LSC Responses to River Bend Crossing TIS Redlines dated March 14, 2020

River Bend Crossing (LSC #184140)

Figure 4

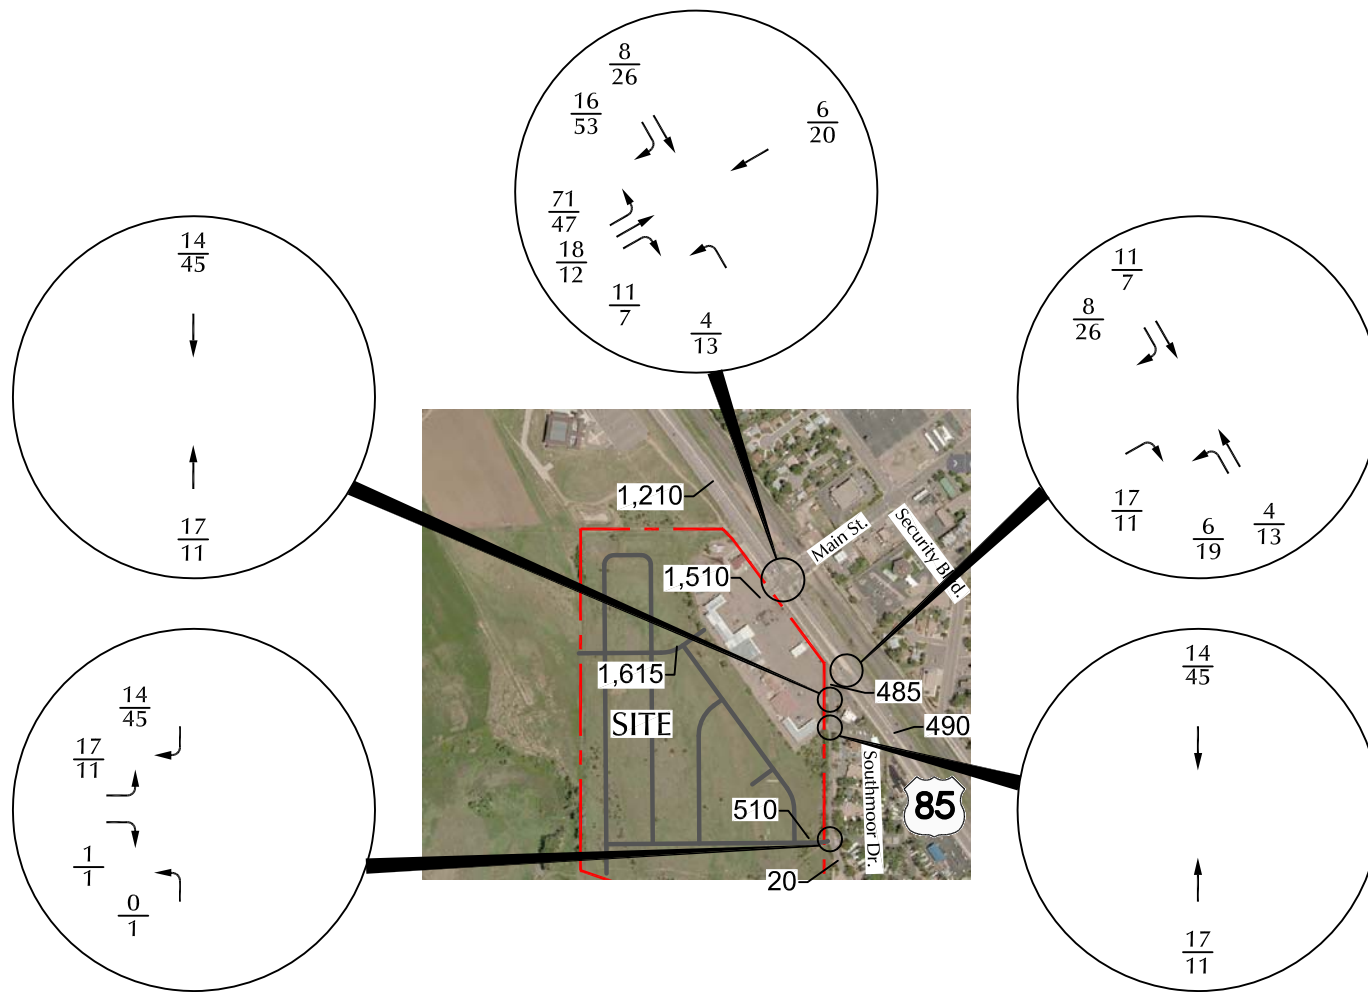
In: $20+35+20+15+5=95$ Out: $25+35+20+15=95$ Add a footnote for the % internal trips captured. Summarize the results of the internal trip estimate tool. In the trip distribution section (pg 5) explain why the directional distribution is 95% in/out instead of 100% in/out.

Why is this 27%. The intersection to the north shows 5+20.

LSC RESPONSE: Updated as requested

LSC RESPONSE: Updated as requested
